Re: 2026/91475- Discharge of details reserved by conditions 6 (bin storage), 7 (crime) on previous permission 2025/93197 for erection of free standing single storey structure to be used as temporary indoor market (sui generis) with associated facilities, office cabins, waste compound, parking spaces and works (within a Conservation Area) at adj, Huddersfield Open Market, Brook Street, Huddersfield, HD1 1RY

Agnieszka Boryn
Designing Out Crime Officer
Kirklees District

Waste Storage Enlarged Plan

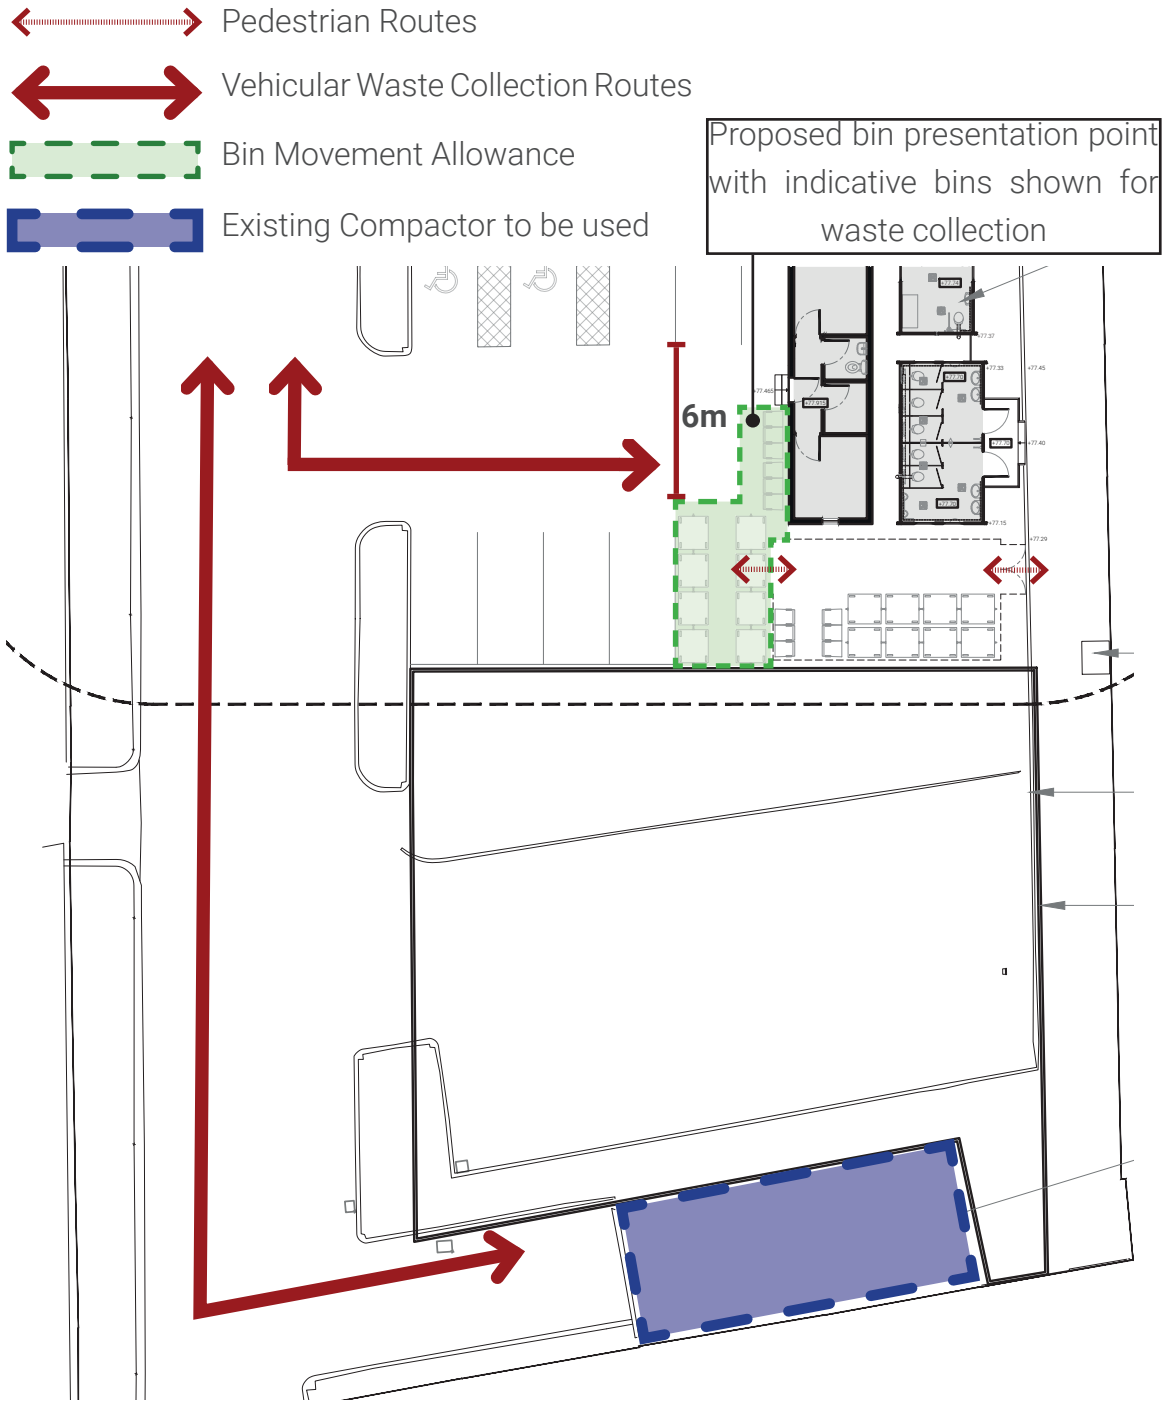
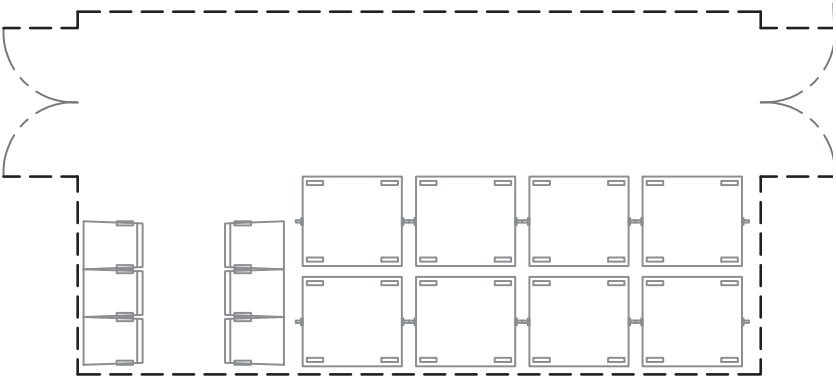
Condition 06- I note that this is a temporary solution whilst the permanent market is under development. The compound is proposed to be secure (gated and fenced), the bins themselves are lidded, panel height is listed as 2m. As part of routine management and maintenance of the site, staff should ensure that the compound is locked and secure outside of operating hours so the bins cannot be removed or repositioned to be used as climbing aids. The fence panels should be linked using couplers of an anti-tamper design.
